Our ref: DOC20/414765

Your ref: SSD-9667

Subject: EES comments on Response to Submissions Addendum for Light Horse Interchange Business Hub – 165 Wallgrove Road and 475 Ferrers Road Easter Creek - SSD-9667

Attachment A

Drawing Name:
Landscape Master Plan

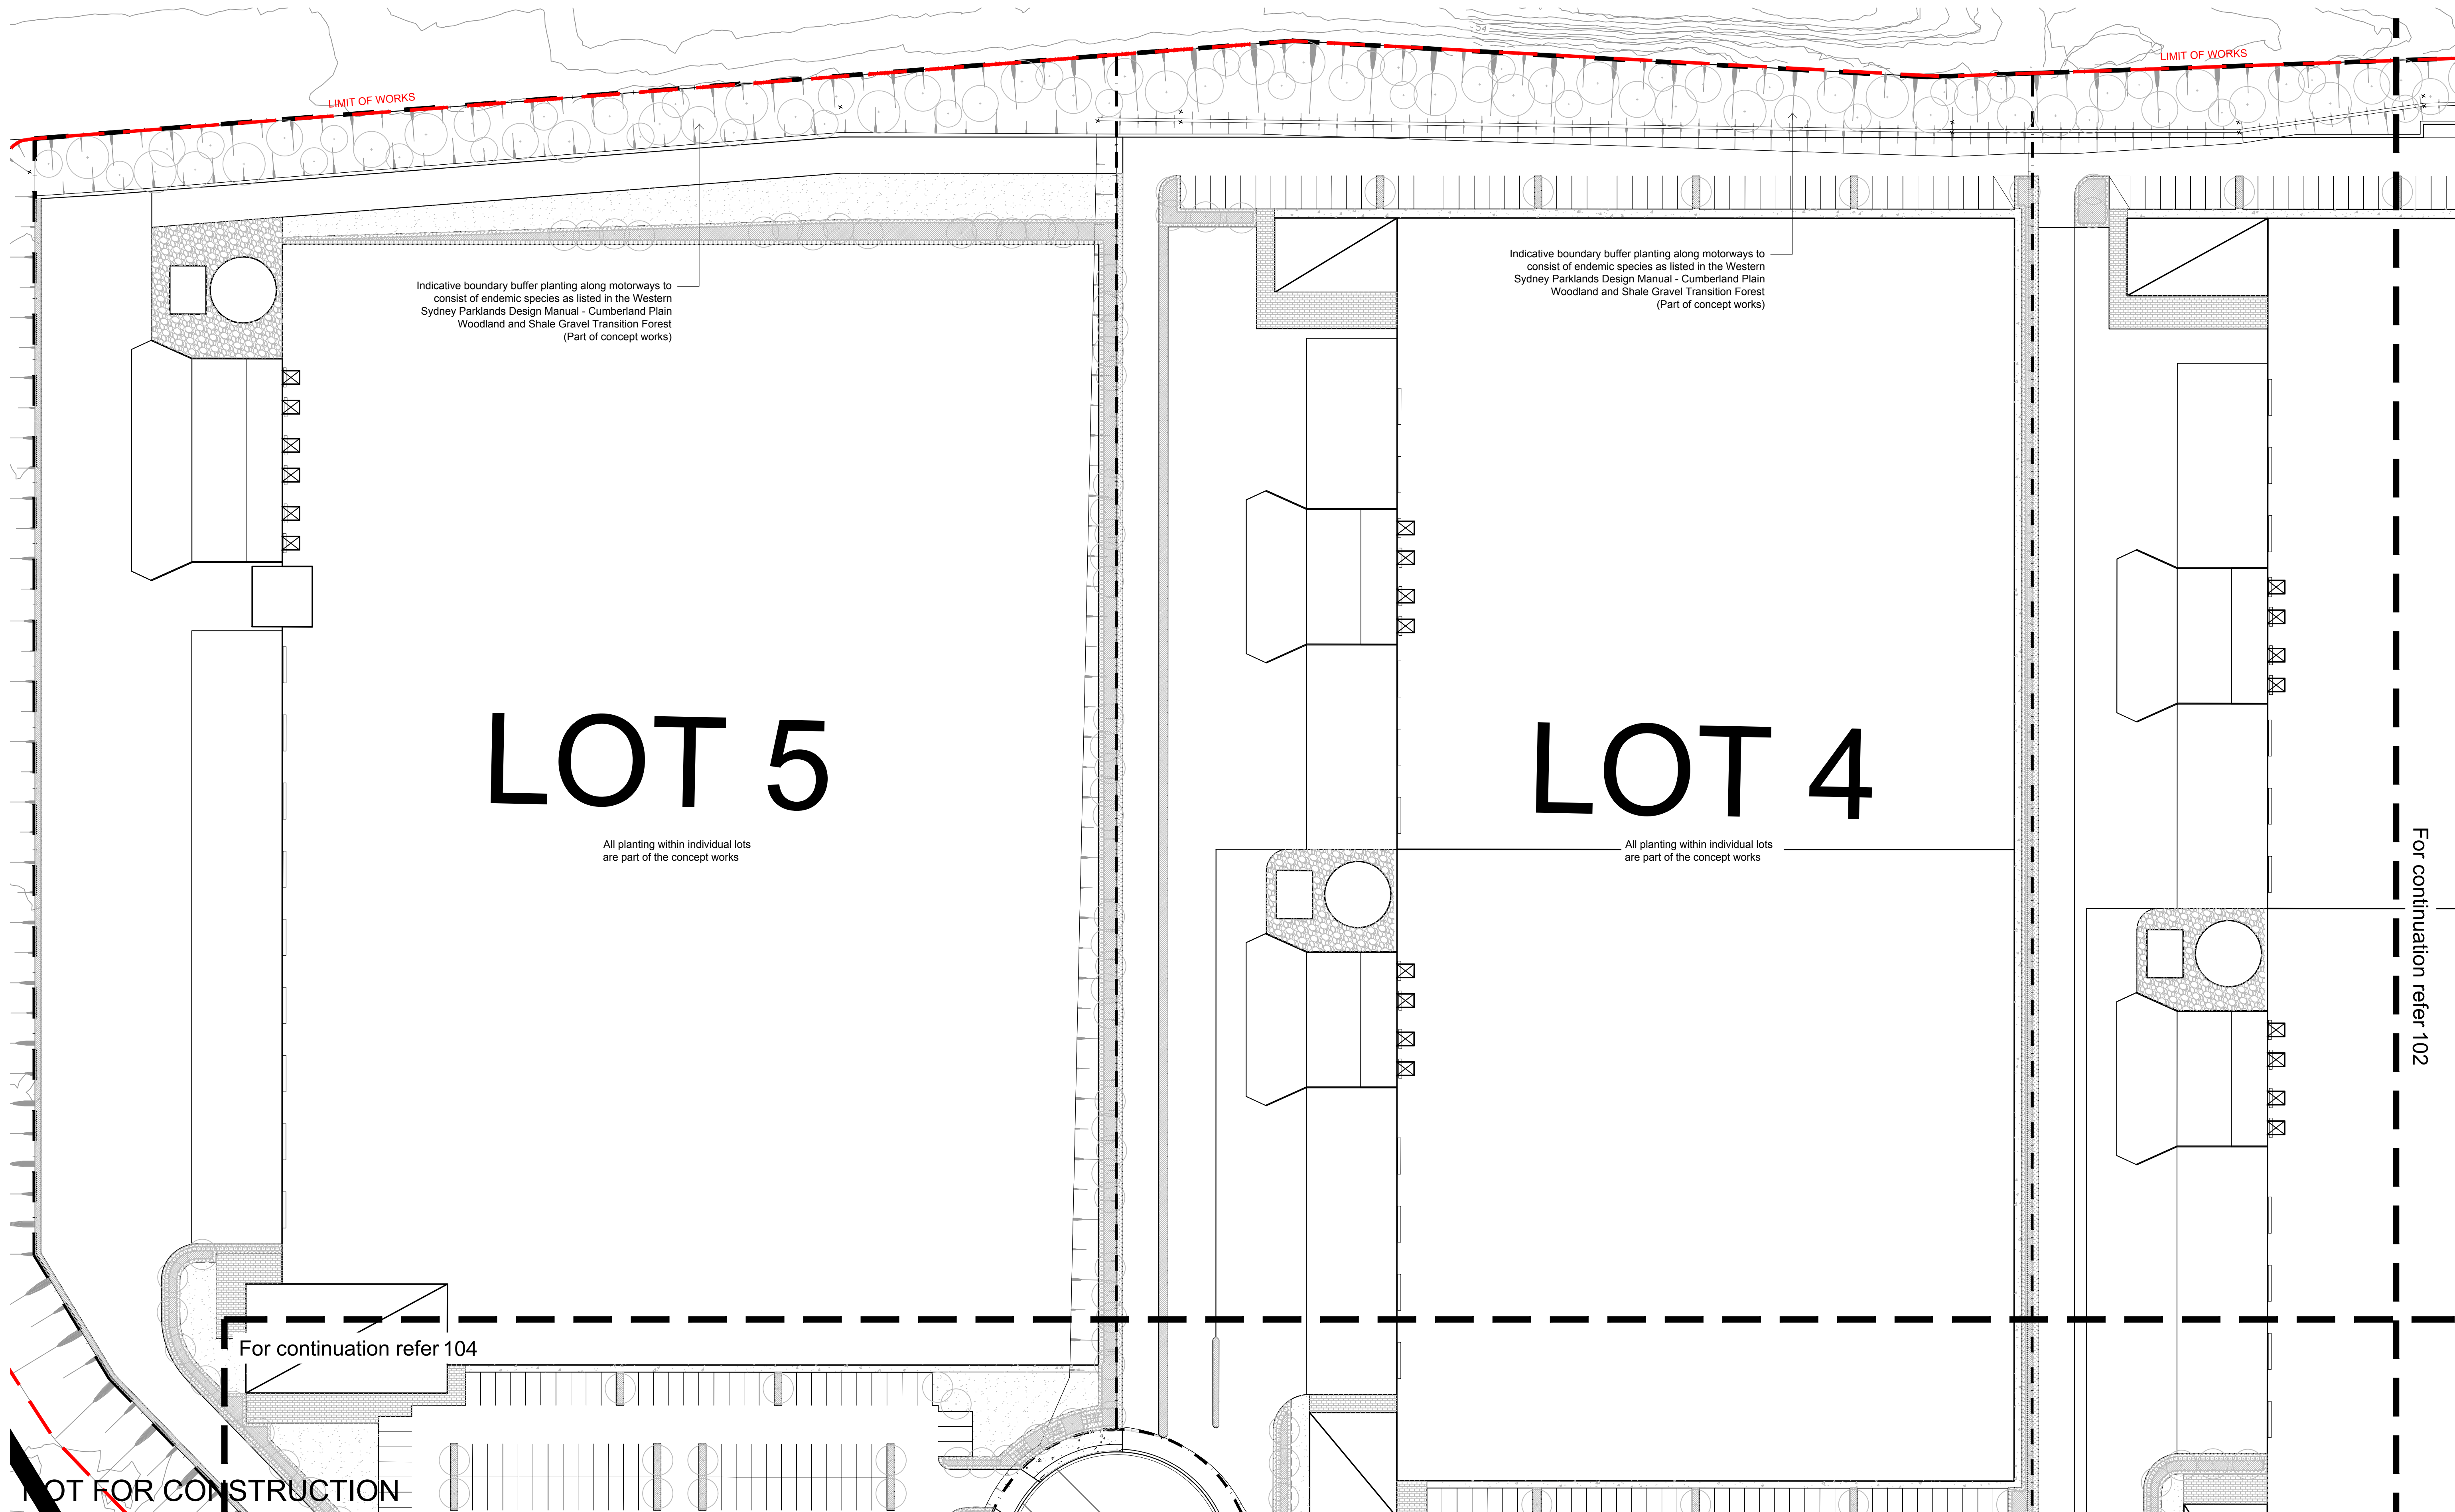
EES previously recommended the Plant Schedule list is amended and a diversity of local native species are planted in the street planting and development lots (rather than plant exotic or non-local natives). EES also recommended the street tree plant list is amended to include Forest Red Gum (*Eucalyptus tereticornis*) because it occurs in the CPW on site. The RTSA confirms that *Eucalyptus tereticornis* has been added to the landscape drawings (page 33). EES notes it has also been added to the street tree and buffer zone planting list.

It should be noted, the loss of 0.38 ha of exotic vegetation will not be offset in accordance with the BAM. EES recommends the applicant maximises tree planting at the site to reduce the urban heat island effect. EES has amended its recommended condition for the preparation of a Landscape Plan accordingly.

A landscape plan shall be prepared for the landscape buffer areas on the site, street planting and trees in the estate basin (Lot 8) and include details on:

- the native vegetation community (or communities) that occur or once occurred in the locality
- a list of local native species to be used in the landscaping from the relevant native vegetation community or communities rather than plant non-local natives or exotic species
- the quantity and location of plantings
- tree planting at the site must be maximised to reduce the urban heat island effect
- the pot size of the local native trees to be planted - advanced and established local native trees preferably with a plant container pot size of 100 litres, or greater for local native tree species which are commercially available. Other local native tree species

01 Mature Tree Space Detail  
502 1:75  
Mature Canopy <8m

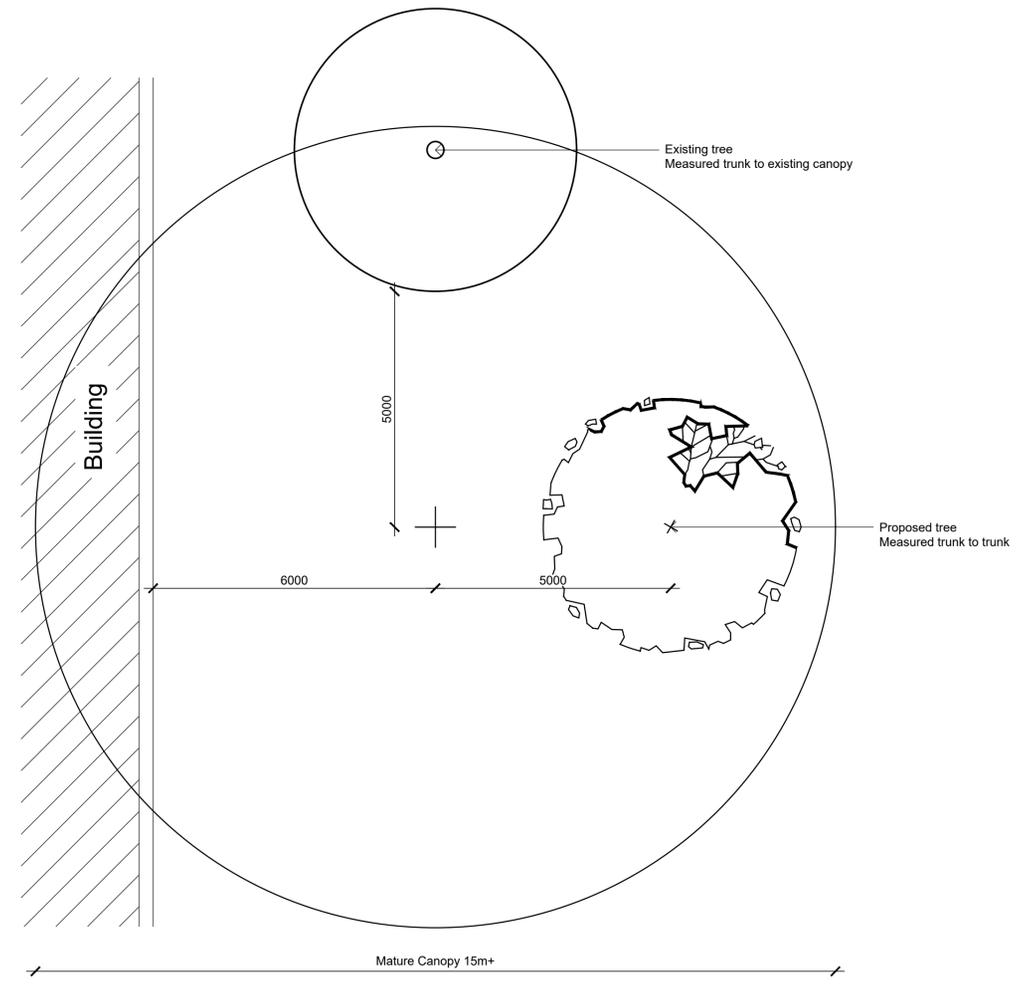
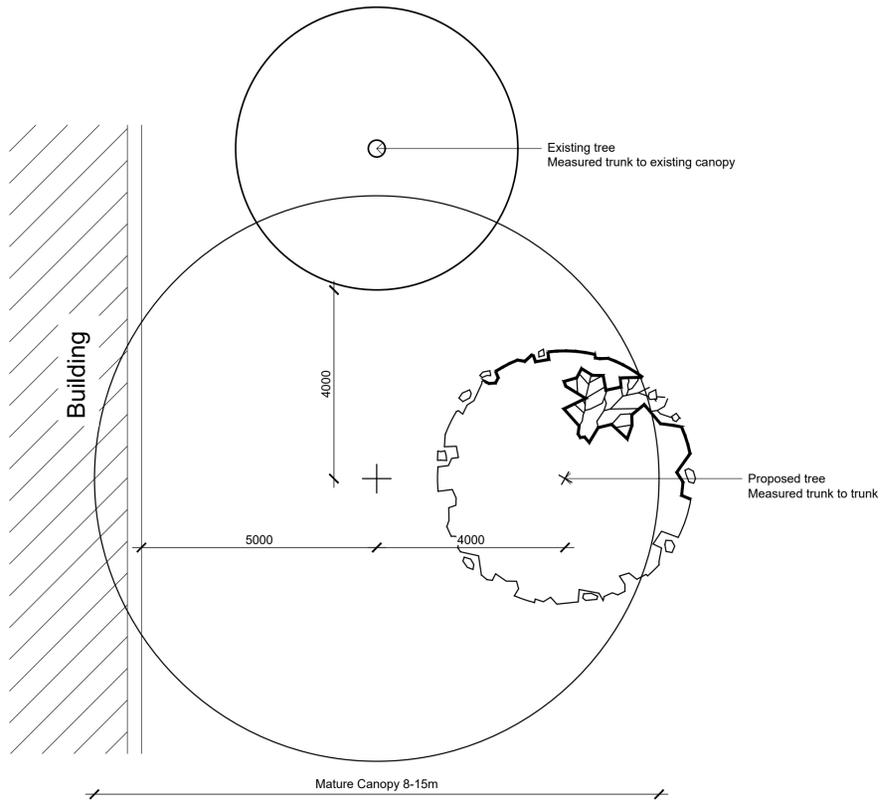
EES advised that sufficient area/space needs to be provided to allow the trees to grow to maturity. The RTSA confirms that the landscape drawings have been updated with mature tree spacing (page 35) but states that it is not spatially feasible for the proposed industrial business hub development to include the planting of all replacement trees within the development footprint at a ratio of 1:1, while allowing sufficient area/space to allow trees to grow to maturity (page 34).

- the area/space required to allow the planted trees to grow to maturity
- plant maintenance regime. The planted vegetation must be regularly maintained and watered for 12 months following planting. Should any plant loss occur during the maintenance period the plants should be replaced by the same plant species.
